DEVIATION REQUEST (Attach diagrams, figures, and other documentation to clarify request)

The proposed new north terminus of Monument Hill Road, as shown on the preliminary plan and in Figure 13 of the TIS, would have the same roadway classification as the remainder of Monument Hill Road to the south (Rural Major Collector). To facilitate the relocated/realigned north terminus of Monument Hill Road farther to the south, several deviations to the roadway design elements are requested for the generally east-west segment proposed for the realigned north terminus. Generally, the request is for design elements more consistent with an Urban Local street, but with some elements consistent with an Urban Collector (such as no parking and no direct lot access driveways).

LSC Responses to Deviation No 2 Comments

Figure 3  
Proposed Realignment  
of Monument Hill Rd  
and Extension of  
Misty Acres Blvd

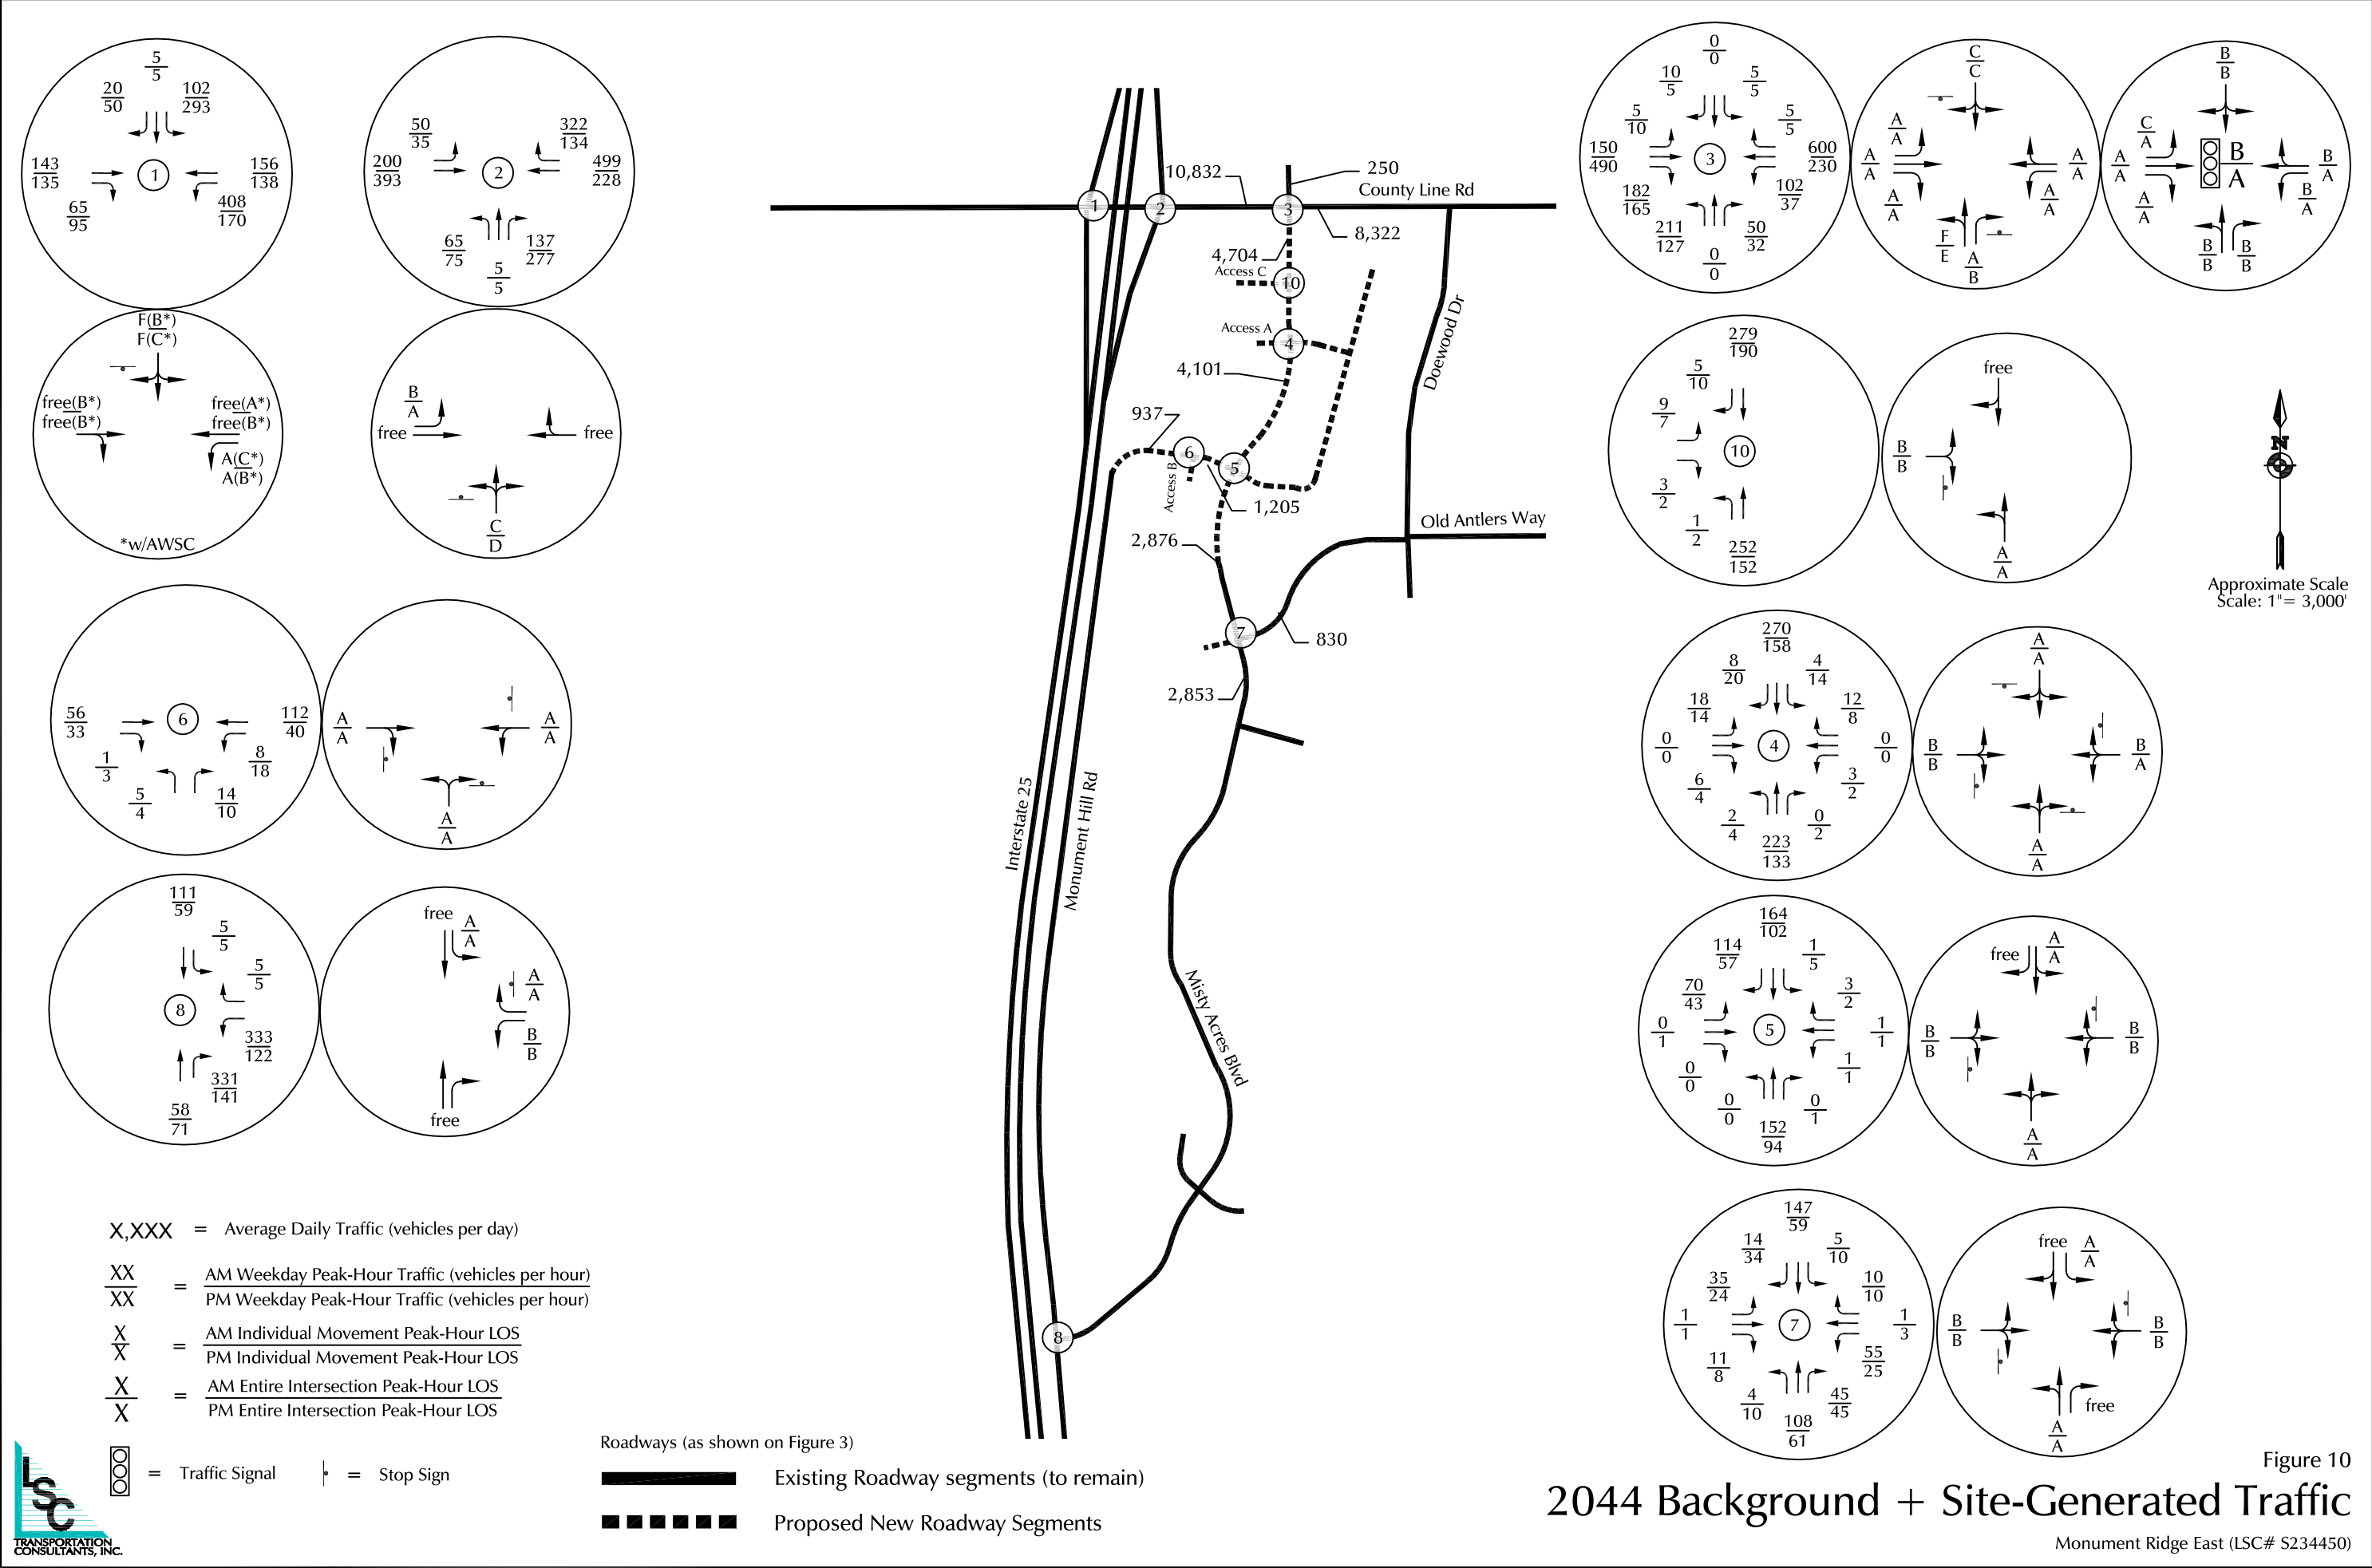
Please clarify if this section is included in this deviation; access does not appear to be the correct section

[Please clarify if this section is included in this deviation; access does not appear to be the correct section](#)

LSC Response: This has been corrected to "2.2.4.A.4"
